Your reference: PA 08_0101 & PA 08_0102
Our reference: DOC12/41339; LIC08/100-06
Contact: Robert Gibson, 4908 6851

RE: INTEGRA OPEN CUT AND UNDERGROUND COAL PROJECTS 75W MODIFICATION (PA 08_0101 AND PA 08_0102 MOD 2)

Figure 5: Existing Biodiversity Offset Areas

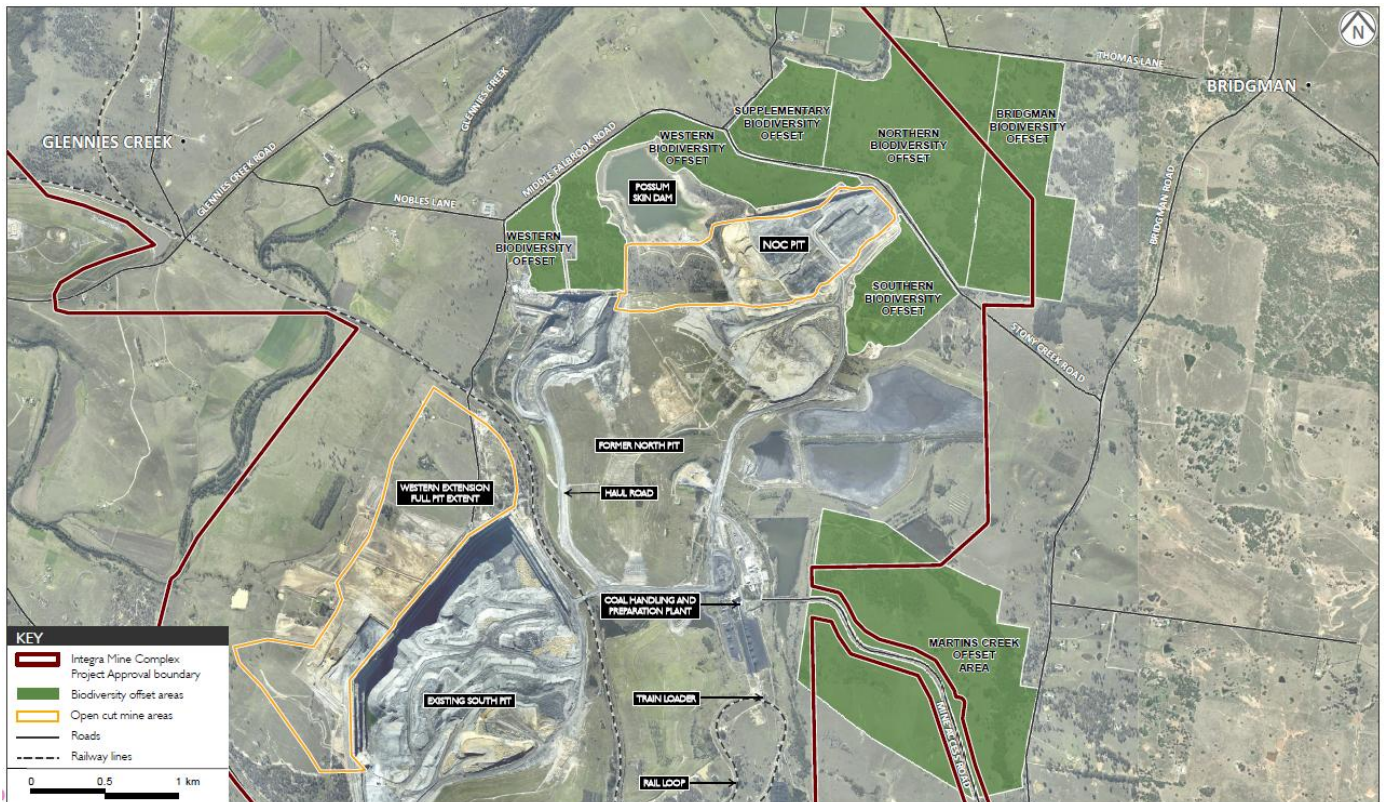
In addition, OEH also notes that Consent Condition 41 in Schedule 3 of the MOD 1 consent makes reference to the figure in Appendix 8 as being a map with a conceptual outline of the offset strategy for the Integra Open Cut and Integra Underground Operations. However, Appendix 8 is a map titled 'Area for Further Archaeological Investigation' and does not show the biodiversity offset required for this project. Instead, Appendix 9 presents three maps that show some of the details of the offset package; the first is labelled 'Figure A. Conceptual Final Landform and Offsets', the second is labelled 'Figure 3.2 Vegetation Communities' (of the Bridgman Offset) and the third is labelled 'Figure 3.9. Conceptual Extended South Pit and Open Cut Project Area Rehabilitated Final Landform'. OEH notes that none of the maps in Appendix 9, or elsewhere in the consent show the Martin's Creek Offset.

OEH therefore recommends that the proponent provides DP&I with an updated map showing all of the currently agreed offset areas (such as Figure 2.1 in the EA for this proposed modification). OEH also recommends that any new consent issued for this project correctly links the maps in the consent to the consent related consent condition to remove ambiguity. This would allow the wording of the consent to better match the intent of the consent, and thus enable the consent to be enforceable.
